01 April 2019
Ref: RH/Let/6181T

RE: Section 73 Minor Material Amendment Application: Proposed minor amendments to Condition 2 and 3 including the external appearance of development permitted under CM/1/19/PL (Variation of condition 10 imposed under CM/12/18/PL relating to hours for all other operations to be from 07:00) at Unit J1, J2 and Z Rudford Industrial Estate, Ford Road BN18 0BF.

2 ROOF PLAN
SCALE 1:100 @ A1

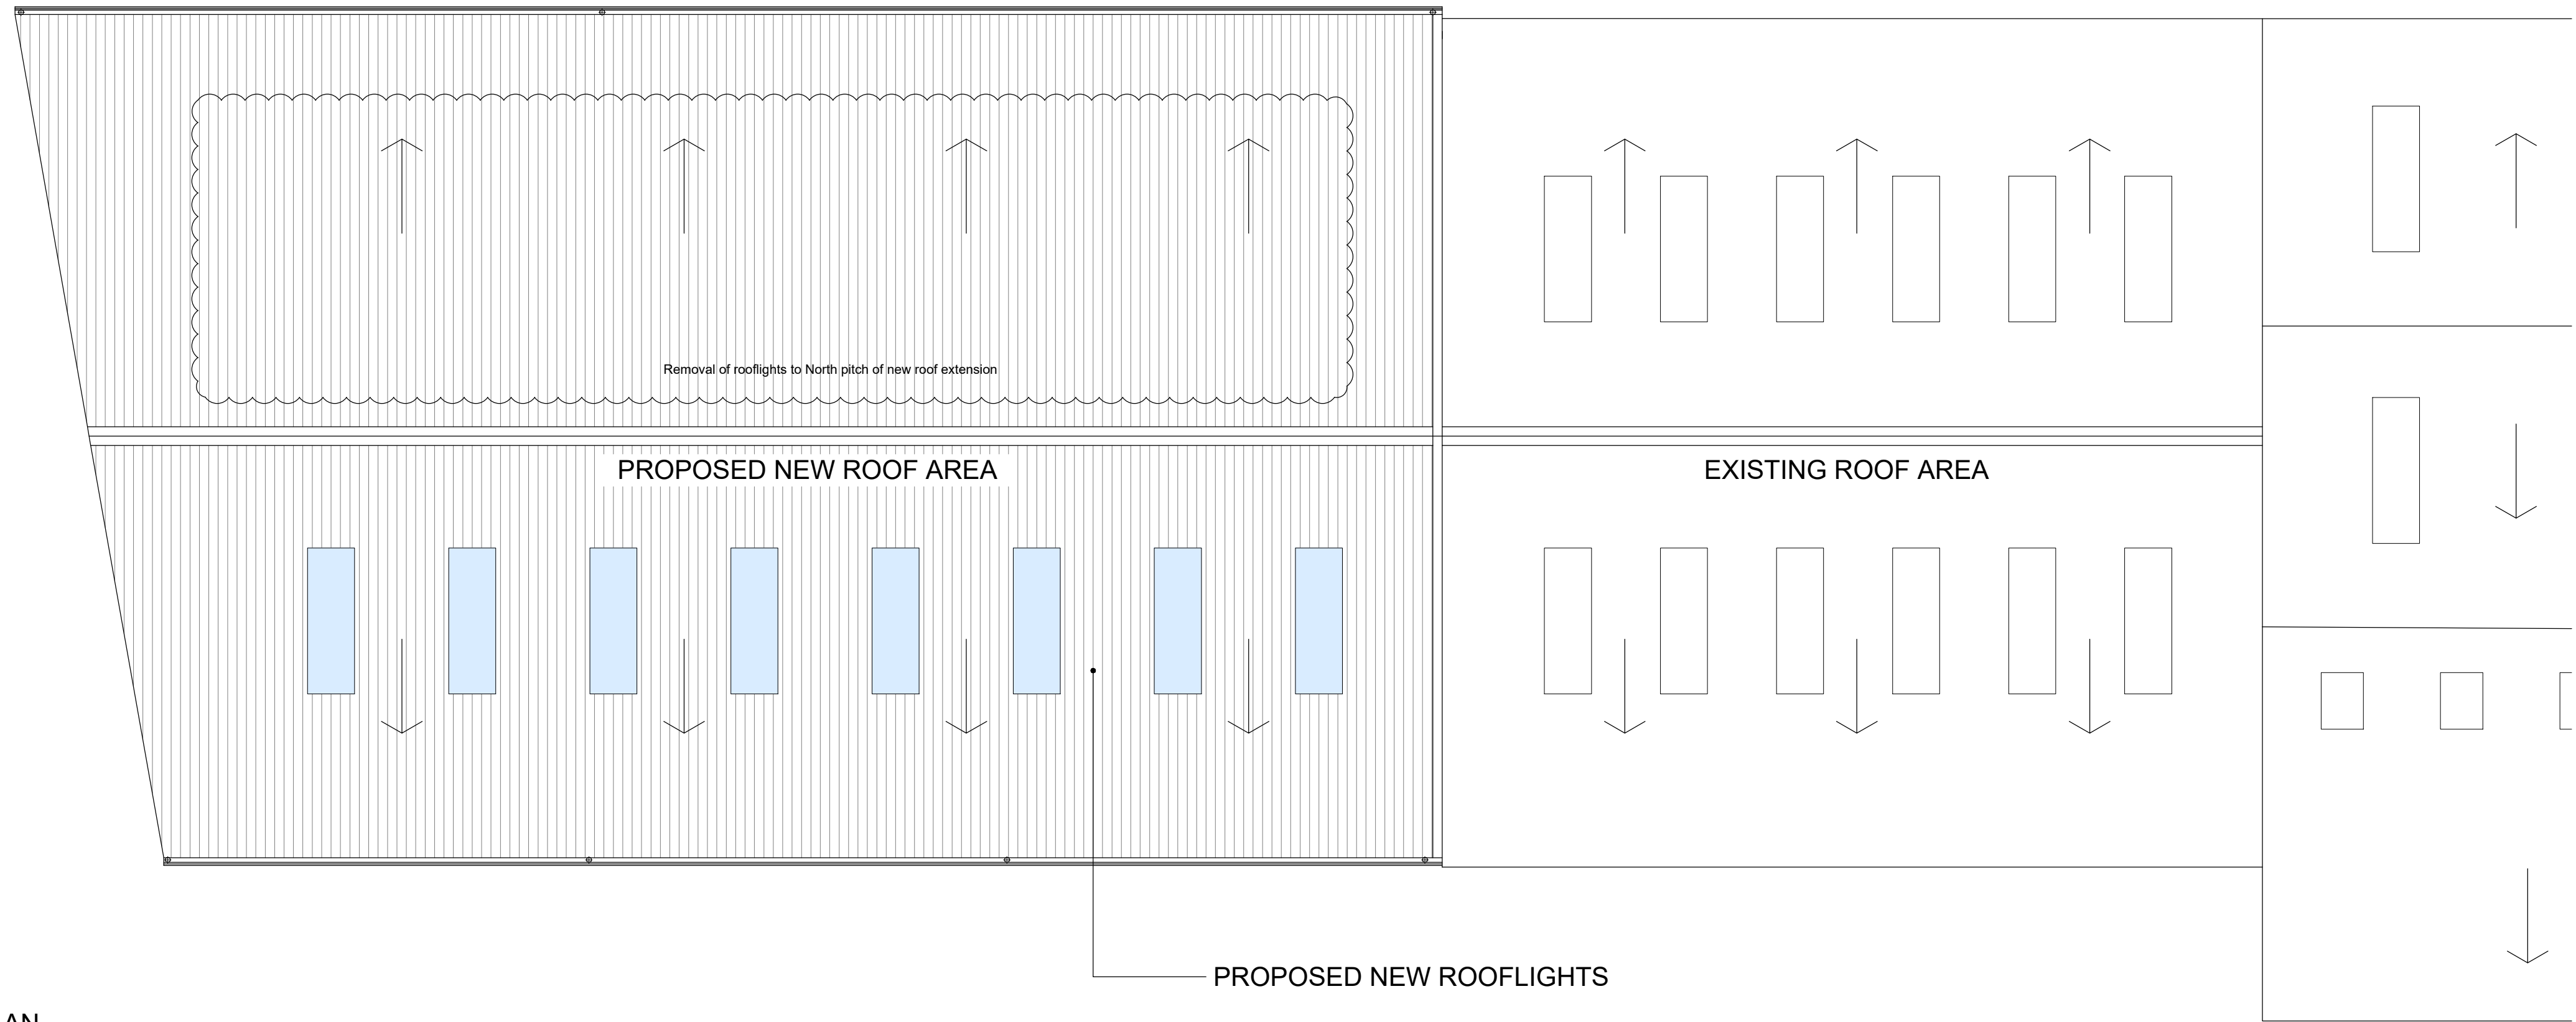
The amendment seeks to remove the northern roof lights to improve the sound performance of the building. This amendment would not be visible from ground level.

1 SOUTH ELEVATION
SCALE 1:100 @ A1

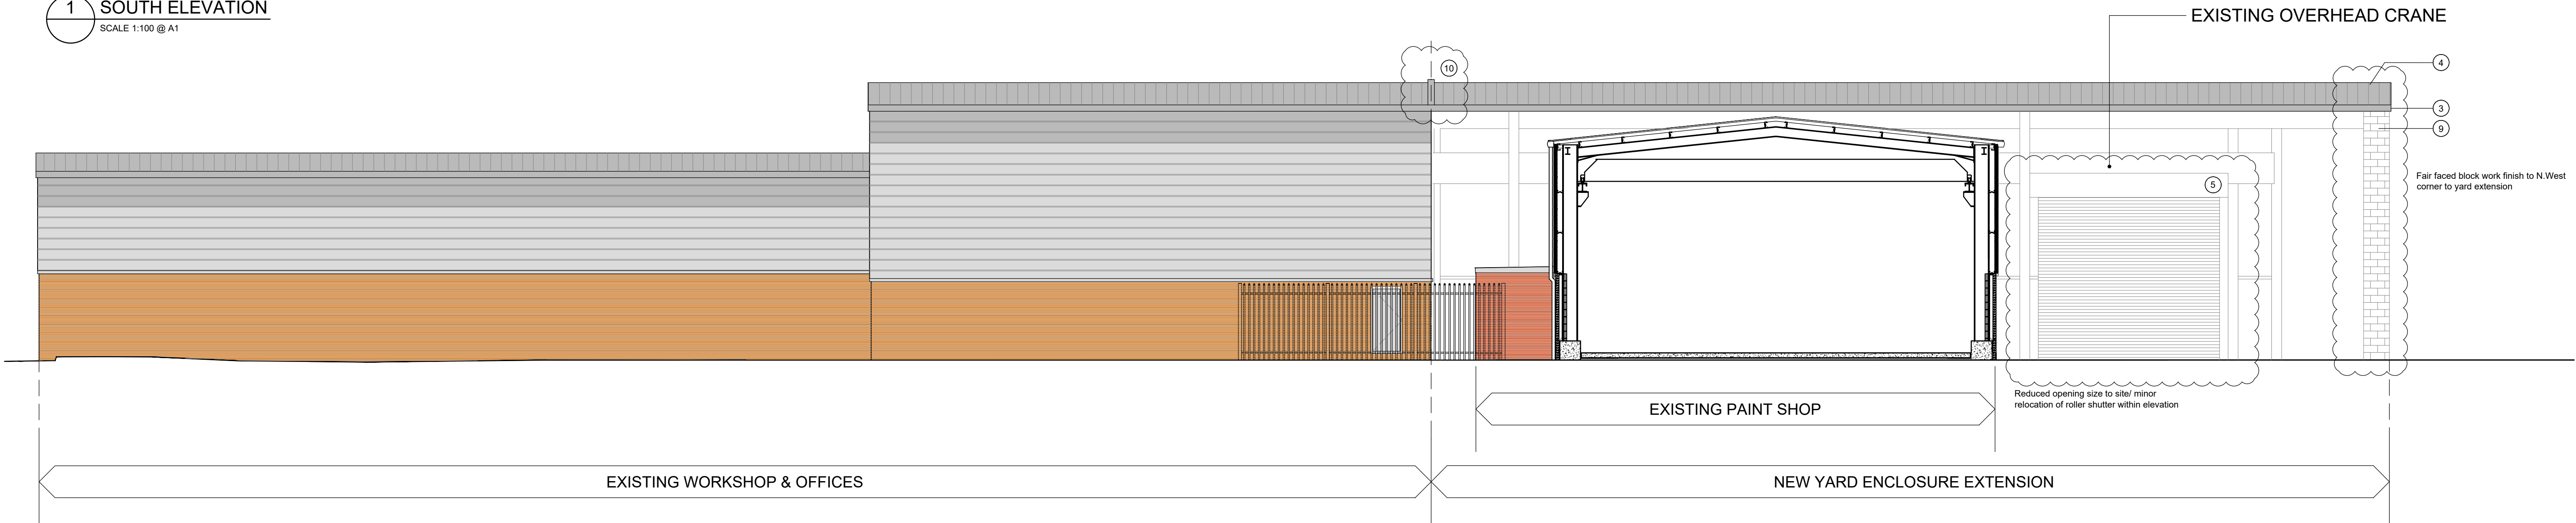
The main change to this façade is the approach to retain the existing cladding on the workshop area and provide internal sound insulation instead. Whilst an amendment to plan 6606 (PL) 007 is required to remove reference to replacement cladding, a small amendment to Condition 3 will also be required to remove reference to acoustic metal cladding to the southern elevation of existing workshop at Unit J1 & J2. We would suggest that the condition could be amended to read:

Further amendments to the southern elevation include a reduction in size for the roller shutter door to allow the internal crane to operate satisfactorily and safely and a new metal upstand profile at the western extent of the new yard enclosure extension and at the join between the existing structure and new extension.

The development of the 'longer term measures' as outlined within section 10 of the Noise Assessment accompanying this application, ref J2407, dated 10-04-2018 by Acoustic Associates, including but not limited to new extension covering the existing courtyard area & appropriate acoustic cladding to the existing workshop at Unit J1 & J2, shall be fully implemented before the expiration of 1 year from the date of permission

2 NORTH ELEVATION
SCALE 1:100 @ A1

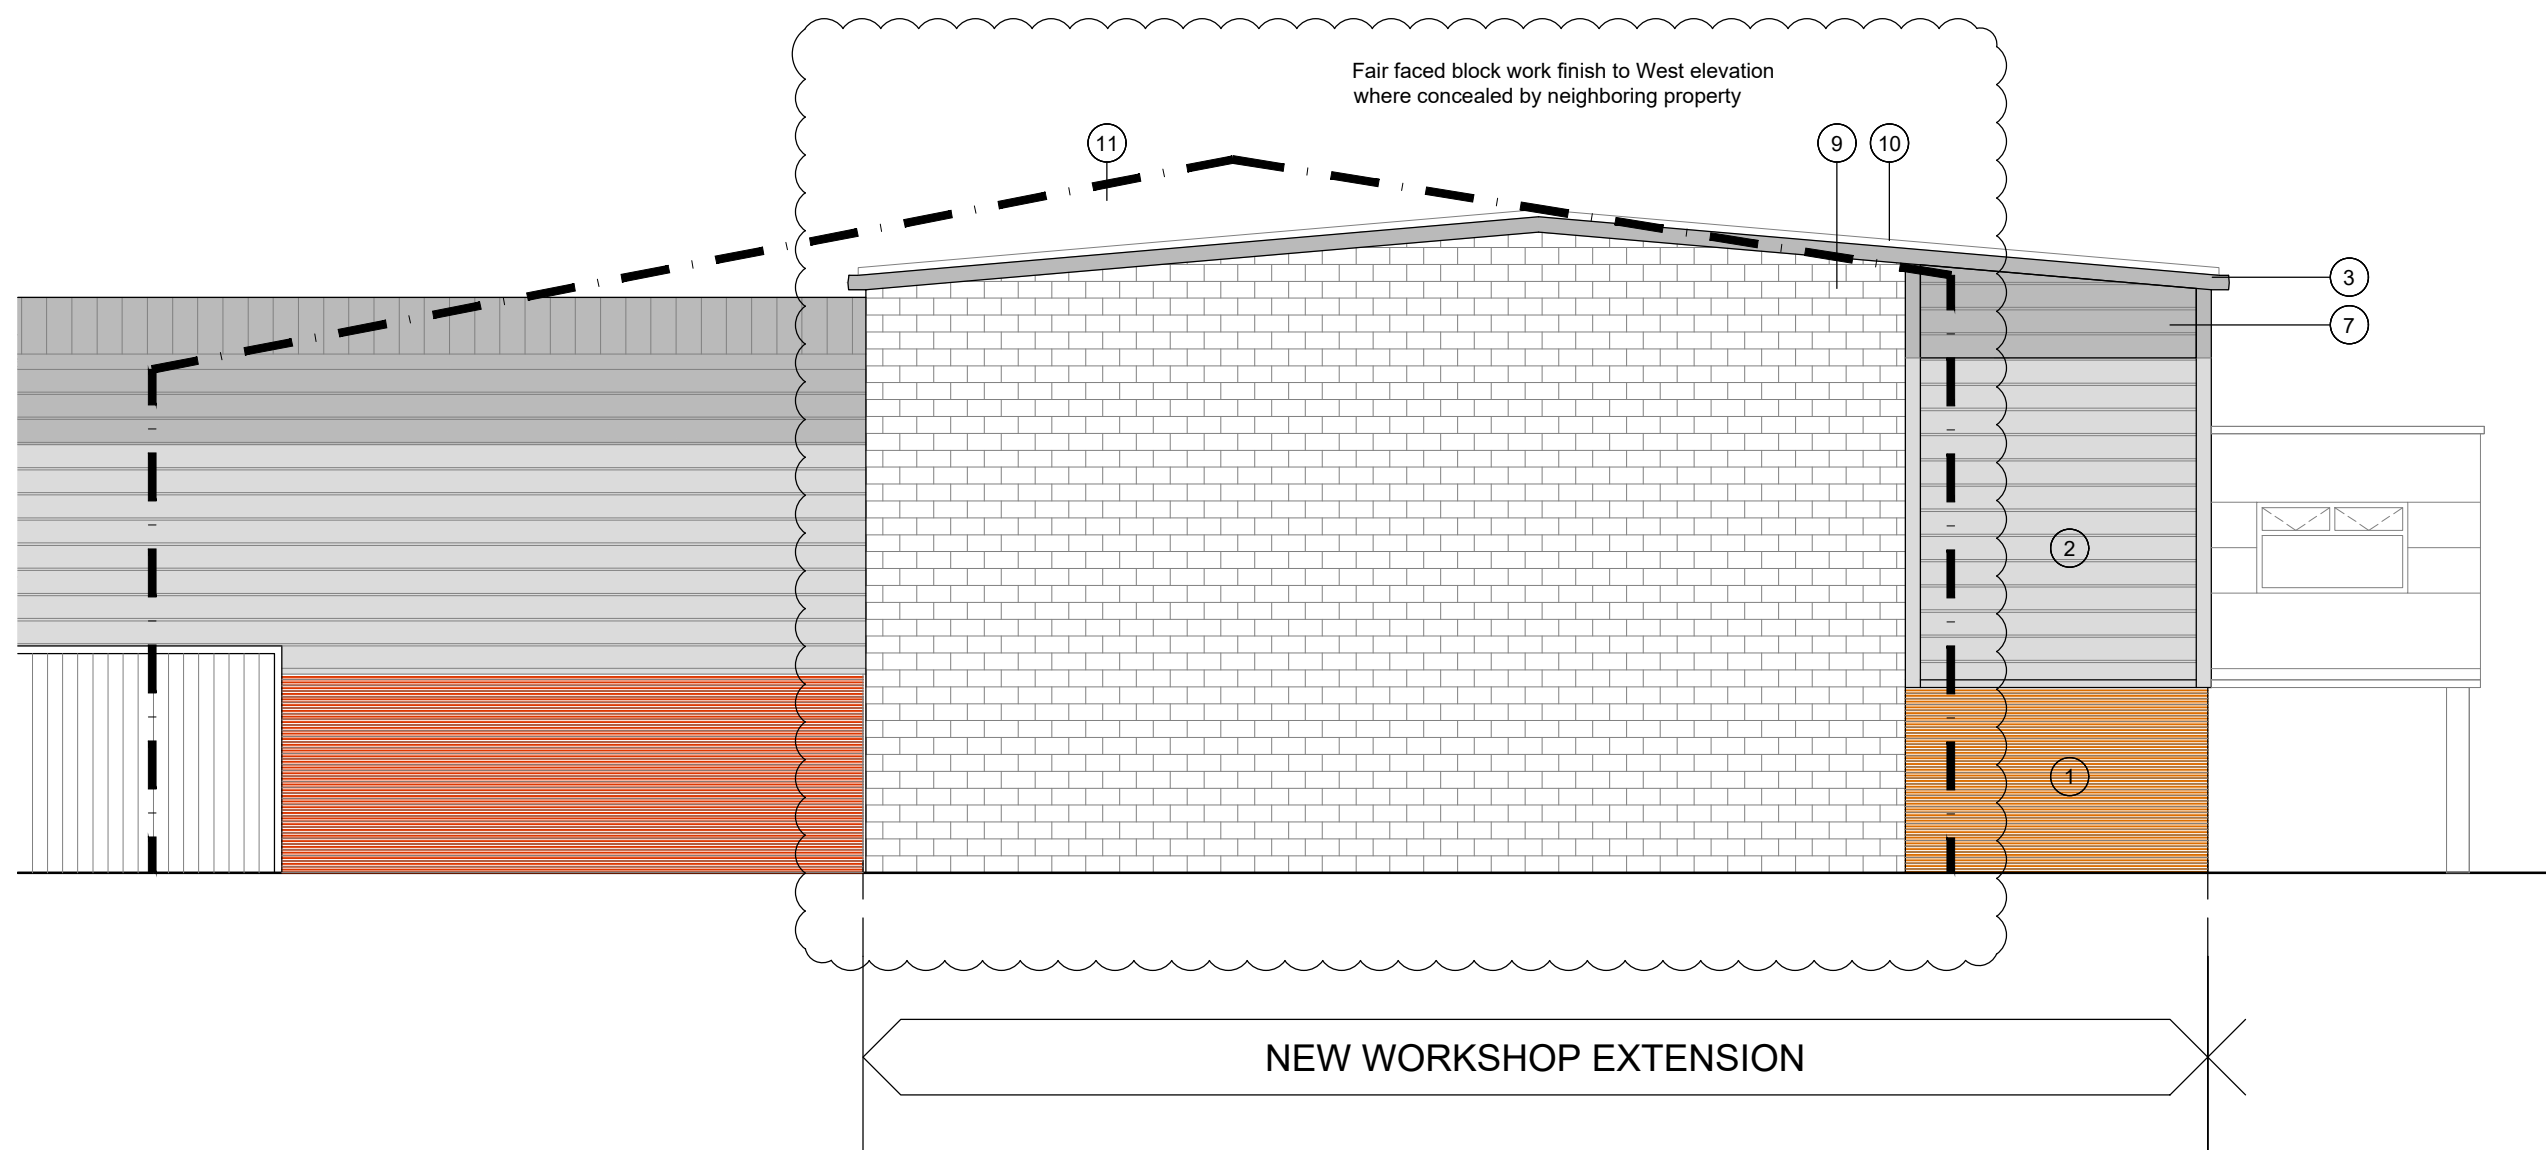
On the northern elevation a small upstand profile at ridge level between the existing workshop and proposed extension building is proposed.

3 WEST ELEVATION
SCALE 1:100 @ A1

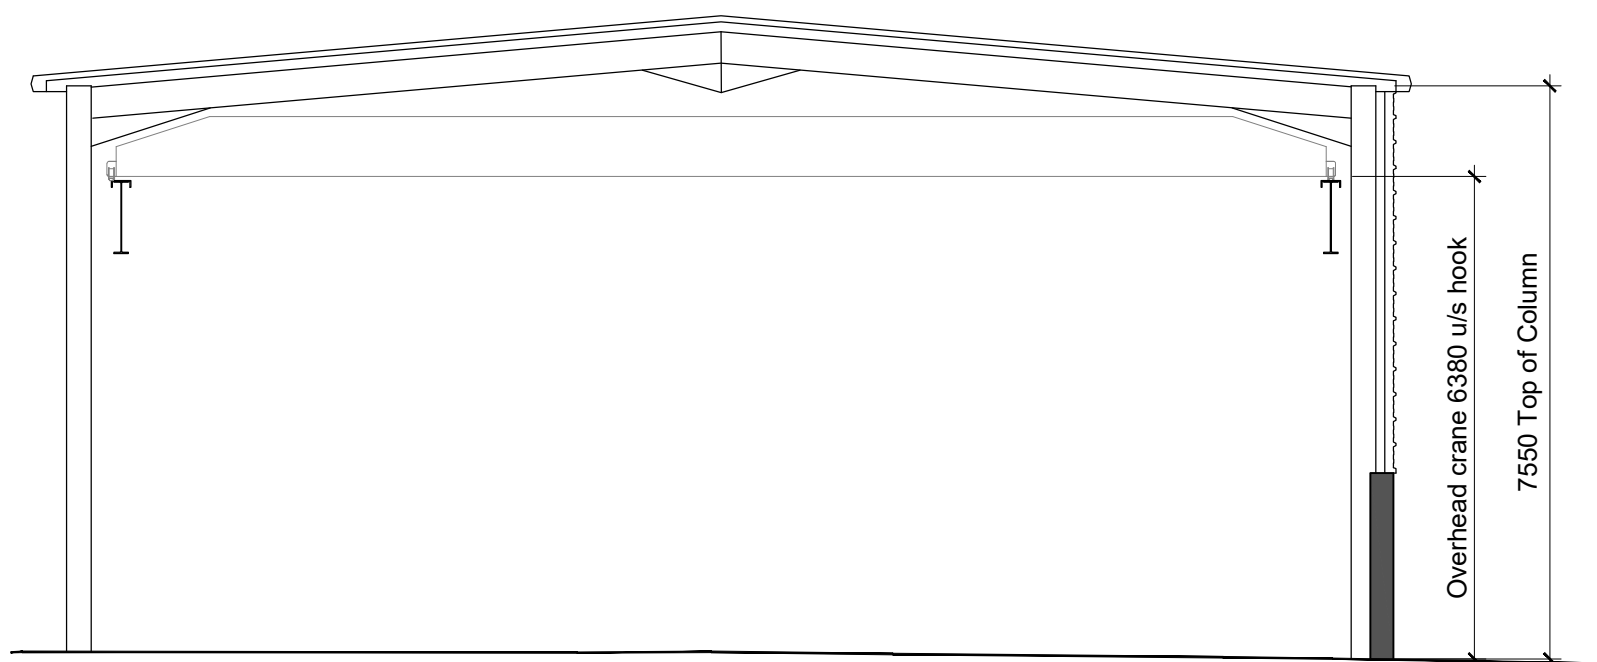
The proposed amendments to this elevation include a metal upstand profile at the southern corner of the extension and an amendment to partially clad the southernmost projection of this elevation with the remaining part of the facade to be faced in brick façade. As demonstrated on plan 6606 (PL) 007 C, this part of the elevation will not be visible and subsequently this amendment is considered acceptable.
